Re: 131, 139, Parkdale Ave and 128 Forward Ave – Urban Design Review Panel Recommendation

On January 9th, 2026 at 9:00am we presented our proposal for a new development located at 131, 139 Parkdale Ave, and 128 Forward Ave. on behalf of our client 11034936 Canada Inc. (Brigil). Included below are our responses to the recommendations made by the City of Ottawa Urban Design Review Panel, dated January 9th, 2026.

Re: 131 Parkdale Avenue - UDRP Comment Response to Landscape Items

1 NORTH ELEVATION
1:200

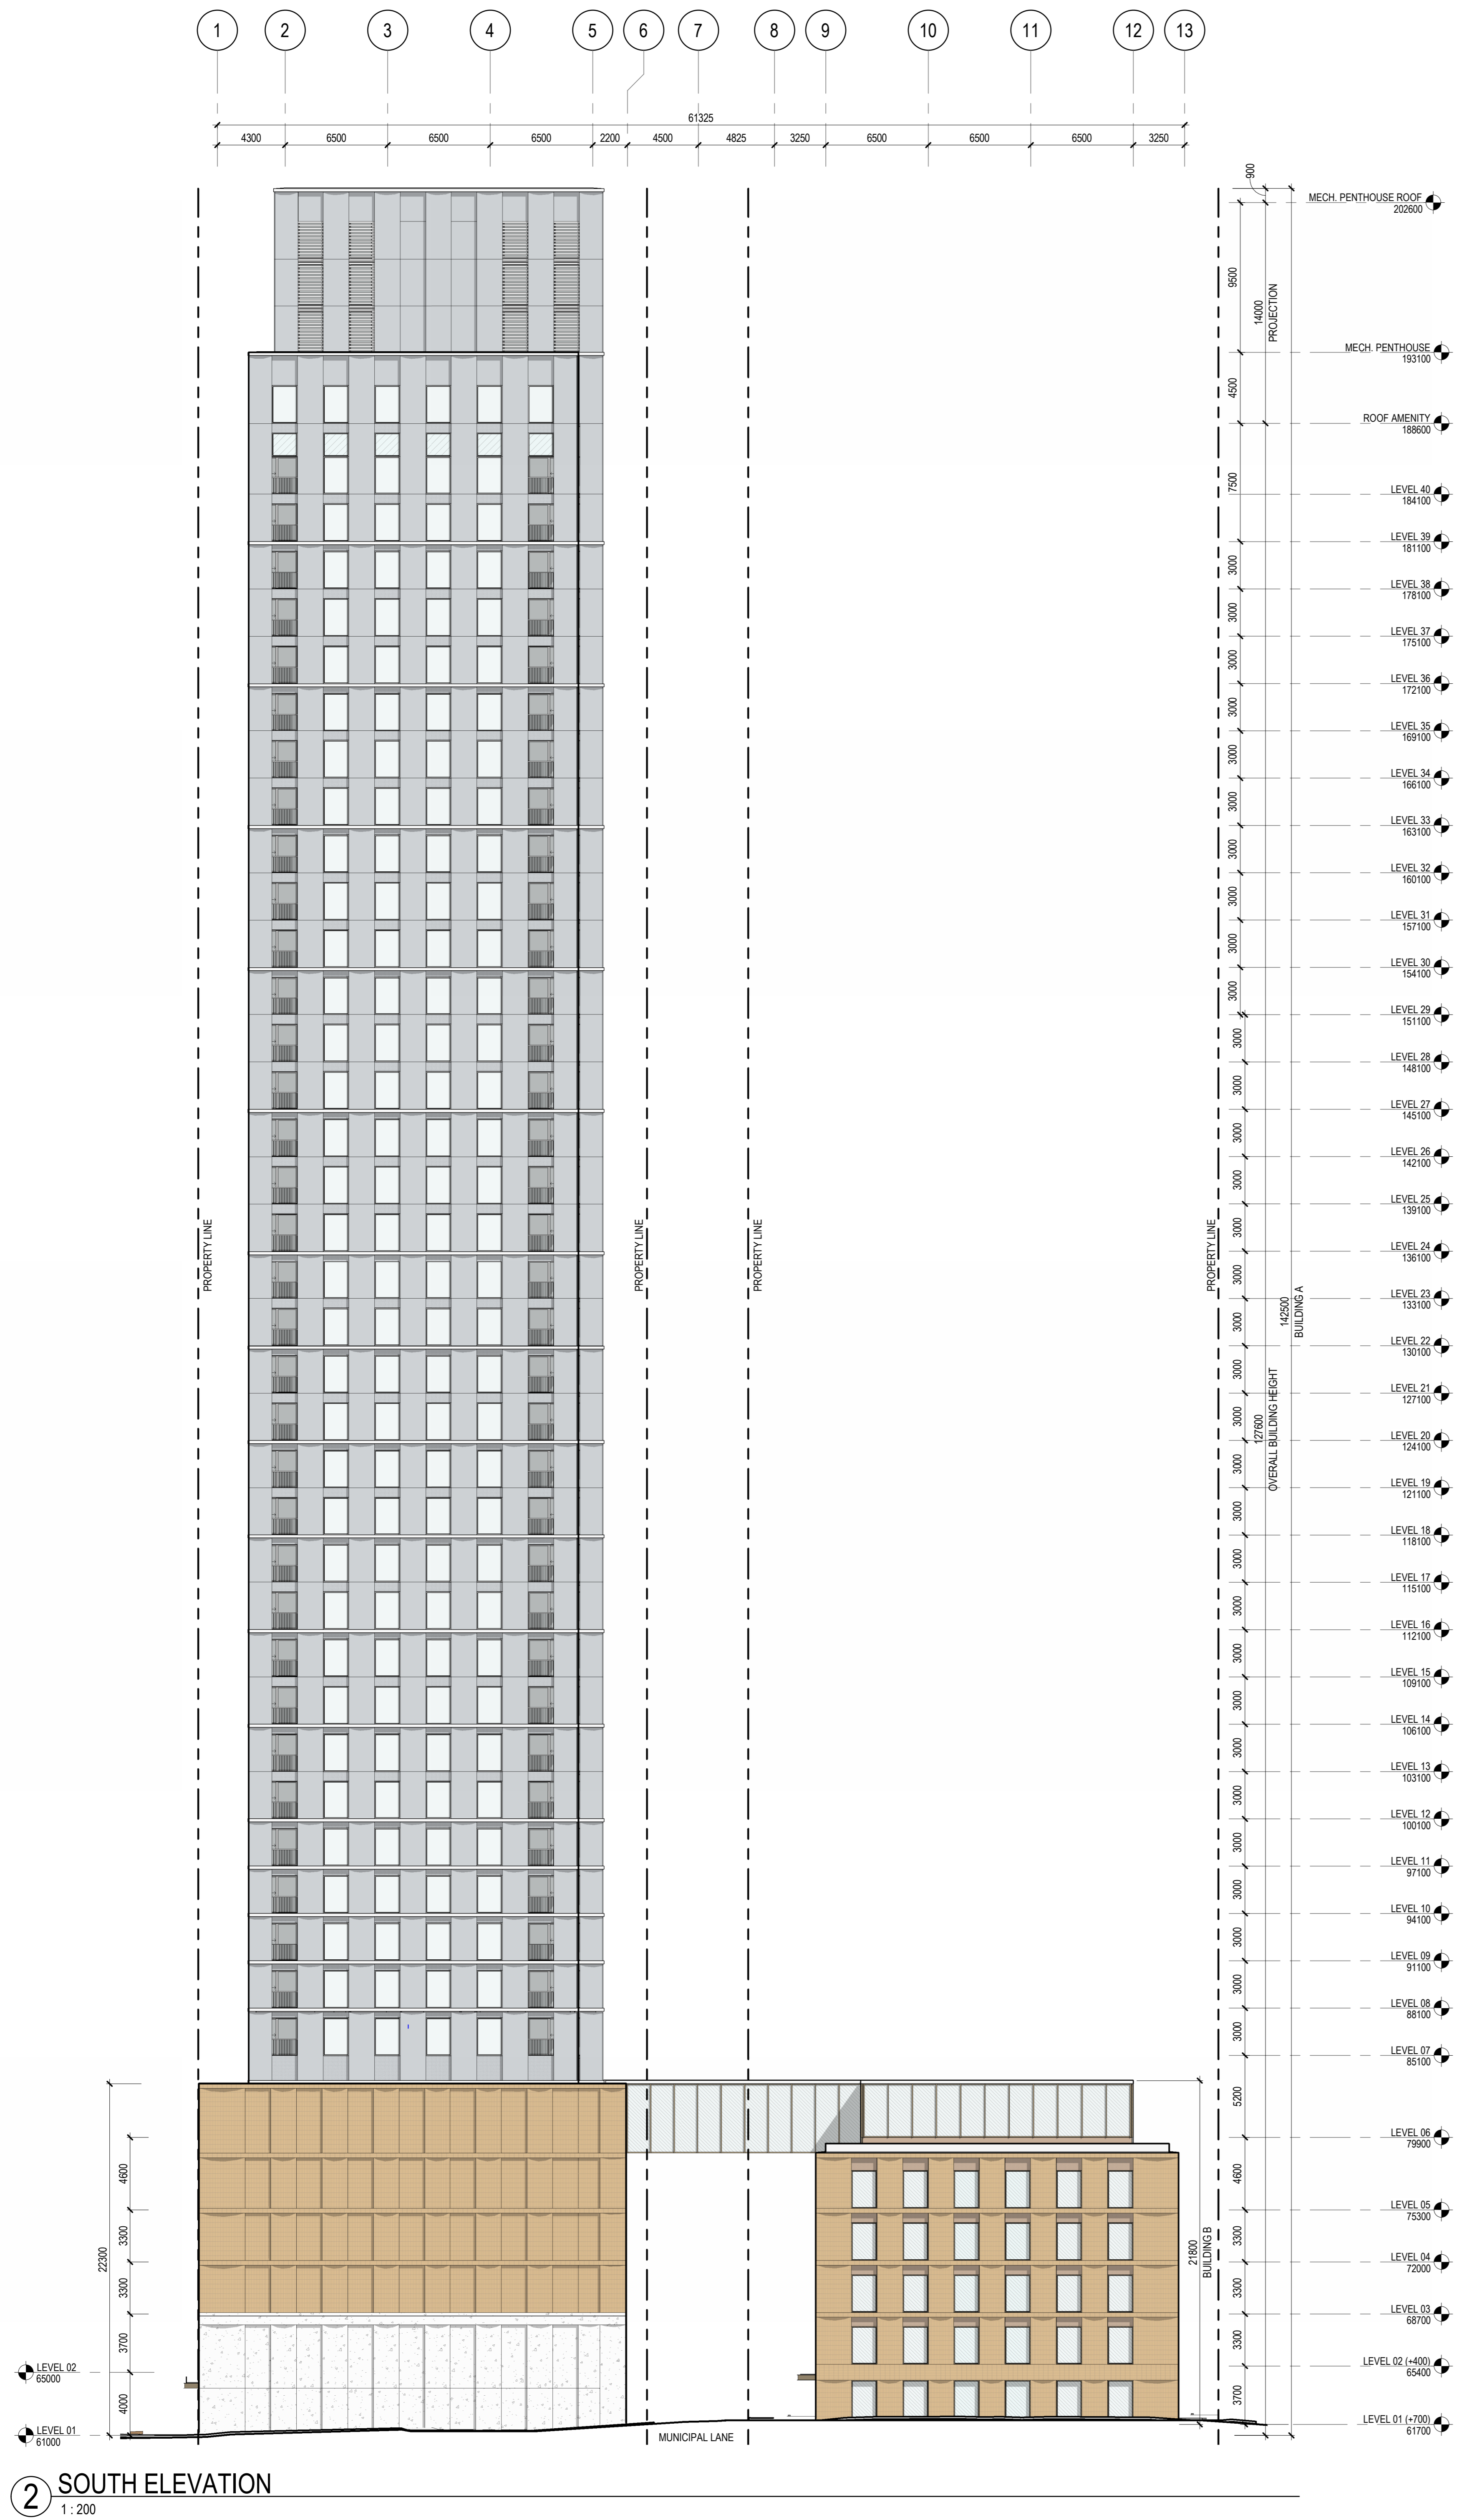
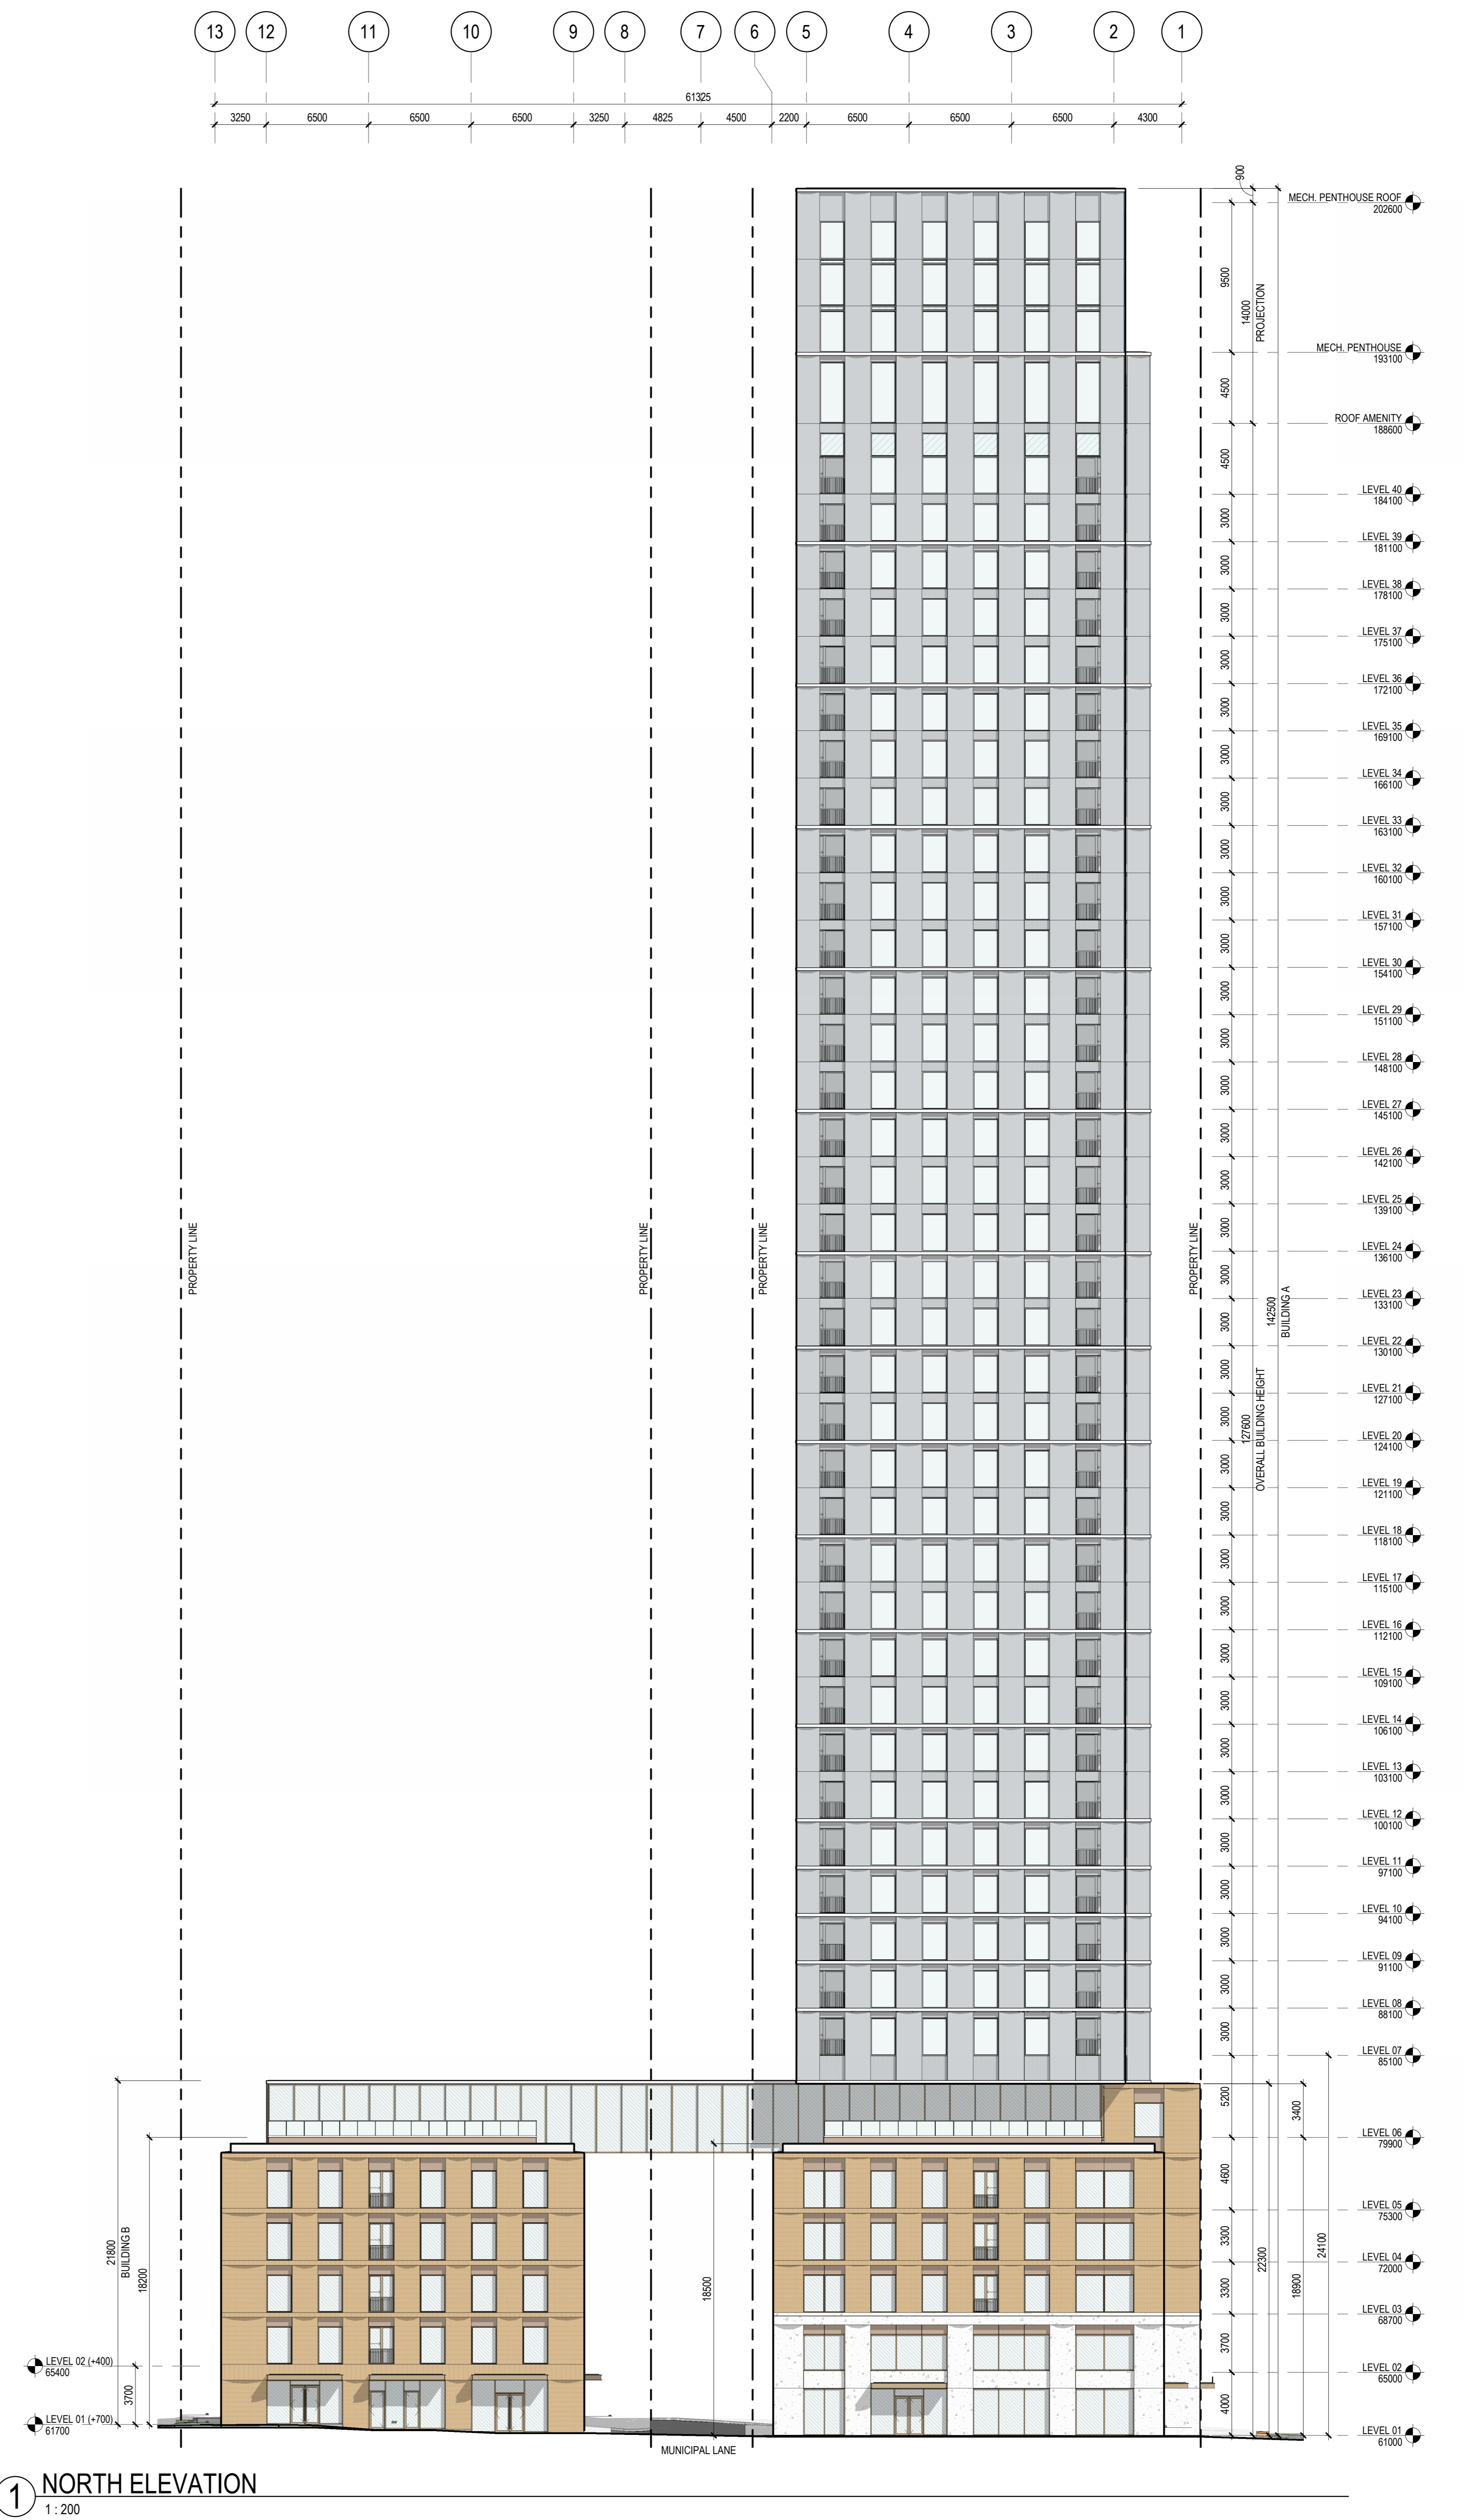
<p>masses into more legible components is appreciated.</p>	
<p>The Panel commends the elegant scalloped vertical elements on the podium and tower and encourages continued exploration of this vertical language.</p> <p><i>The current 1.6-metre shift may not sufficiently read as two slender towers, a complementary vertical reveal and strategic balcony placement are recommended. Precedents such as CIBC Square (even though that is an office building) in Toronto are worth studying.</i></p> <p><i>The Panel also questions the necessity of horizontal elements, suggesting the design could more clearly celebrate verticality and enhance the base-to-sky expression.</i></p> <p>The Panel encourages further development of the tower top, supporting a lantern-like treatment to screen mechanical areas that enhance the building's visibility and presence on the Ottawa skyline.</p> <p><i>The Panel appreciates the reveal floor and banding strategy, and encourages continued refinement of corner conditions, material transitions, and base proportions to reduce perceived heaviness and improve the pedestrian experience at grade. The transition between the tower, podium, and lower building is generally well handled, with continued fine-tuning encouraged.</i></p> <p><i>The Panel supports the direction of the smaller midrise building in the composition, siting it as a potential transition approach for similar tower sites in the Tunney's Pasture district.</i></p>	<p>Noted. As part of the development of the massing a reveal between the two masses of the tower was explored. As presented, the two masses are of equal width and length in plan with the same number of windows and vertical panels. Two strategies were explored to create a reveal while maintaining the integrity of each mass for the height of the tower.</p> <ol style="list-style-type: none"> 1) We explored shifting the south mass further to the south to introduce a reveal between the volumes. This increased the floor area of the tower and reduced the tower separation to the south. 2) We explored pushing part of the southern volume in to create a reveal between two unequal masses. In elevation this resulted in an unequal number of windows and solid vertical panels which we felt undermined the clarity and elegance of the composition. <p>In both strategies, while the masses were expressed as more separated in elevation, the reveal had the unintended consequence of reducing the difference of the facade alignment between the buildings in perspective, especially as one approached the building from the north. For this reason, we have chosen not to incorporate a reveal between the volumes of the tower.</p> <p>As noted previously, we have continued to refine the exterior, including</p> <ol style="list-style-type: none"> 1) incorporating horizontal brick bands within the podium to create a more residentially scaled expression, 2) shifting the larger horizontal datum within Building B that separated level 2 and 3 down to level 1 and level 2, bringing the scale of the building down and in greater alignment with the existing residential fabric particularly the MURB at the south-east corner of Burnside and Forward, 3) the introduction of Juliette and inset balconies within the podium, including metal picket guard, 4) the introduction of additional canopies along Parkdale to align with

<p>the amenity spaces, lobby, and bicycle parking entries,</p> <p>5) adjusting the floor to floor to align with proposed brick modules</p> <p>6) the introduction of steps and small front terraces at the at-grade units along Forward Ave.</p>
<p>The Panel supports the reveal floor and the material treatment of the podium and appreciates the study of the scallops to ensure their legibility and as a strong character defining element of the design.</p>	<p>Noted. As the design evolves and is refined, we will seek ways to make the scallop expression legible.</p>
<p>The Panel encourages the proponent to explore making the bicycle rooms on both buildings more activated to contribute to the streetscape design of the mid-block connection rather than inward facing storage spaces.</p>	<p>As noted above, the bicycle rooms are envisioned as daylight spaces that contribute to the experience of the public realm and put active transportation on display. We are exploring ways to create connections between these spaces and the exterior as well as putting this amenity on display to the interior of the building.</p>
